MECKLENBURG COUNTY
Park and Recreation Department

MEMORANDUM

RE: Rezoning Petition # 2008-073 (PID #s 075-105-43, 075-105-30, 075-105-37, 079-044-02, 075-111-01, 075-124-02, 075-123-01, 075-112-01, 079-043-03, 075-114-23, 075-114-24, and portions of 075-113-04 and 075-113-01.

TECHNICAL PLAN

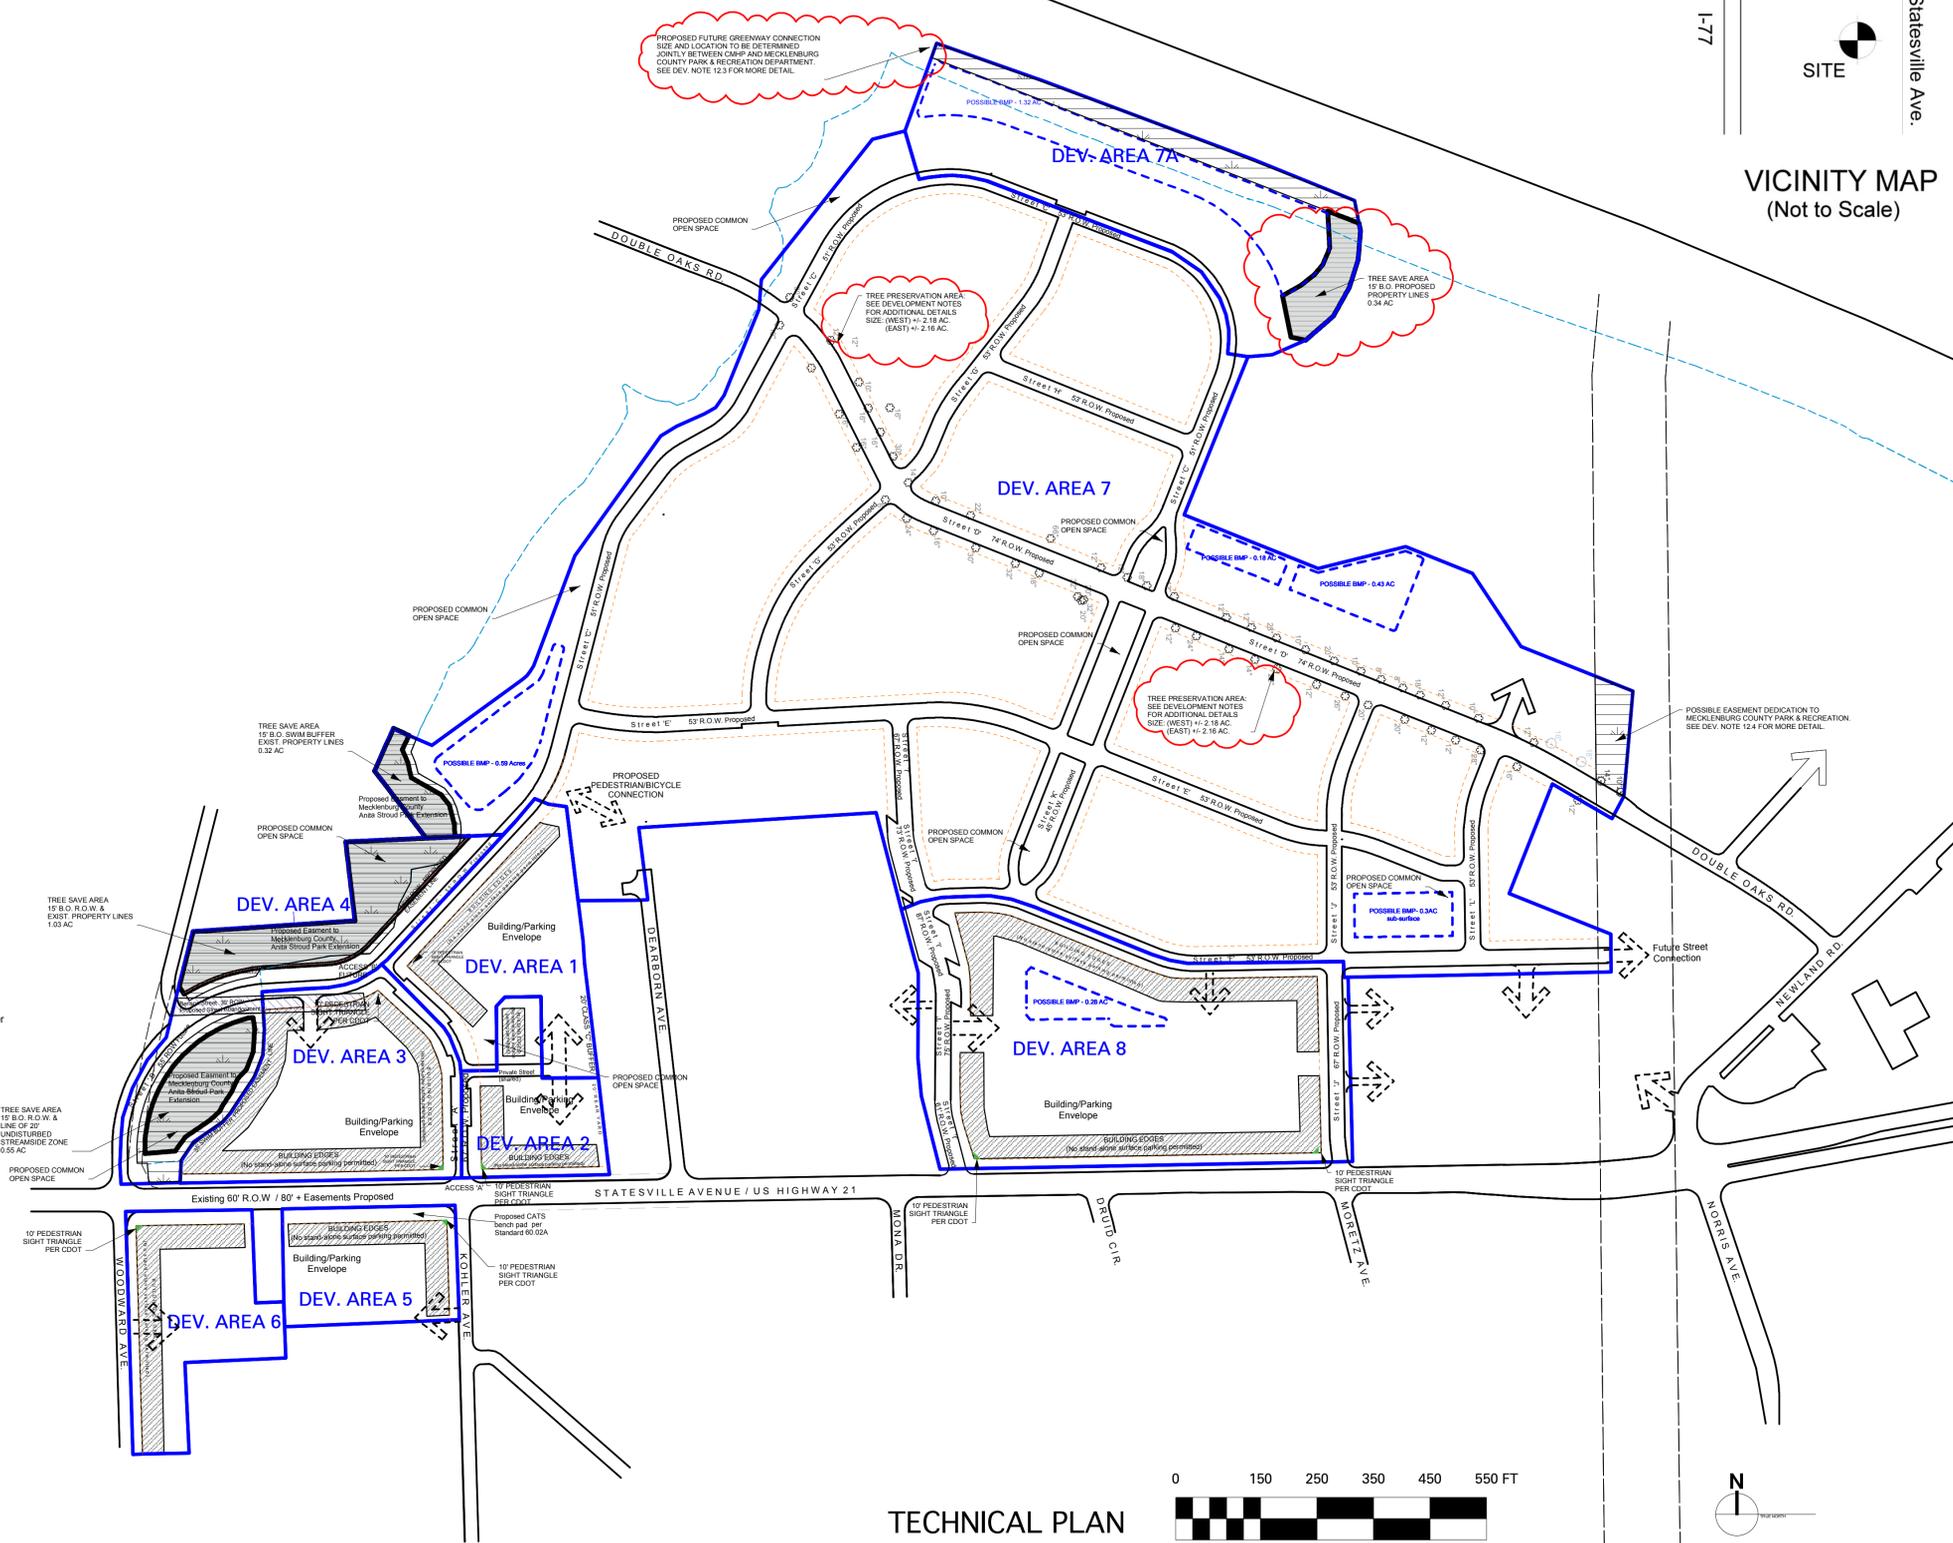
MCPR recognizes and appreciates the petitioner's "proposed easement to Mecklenburg County" as illustrated in the Technical Plan in between the eastern end of Anita Stroud Park and Development Area 4 of RP# 2008-035. This will allow for a pedestrian connection from Statesville Ave. through easements dedicated during RP# 2008-035 to Anita Stroud Park and the future Irwin Creek Greenway. As shown in the Technical Plan for RP# 2008-073, no BMP should encroach on the easement area to be dedicated to MCPR.
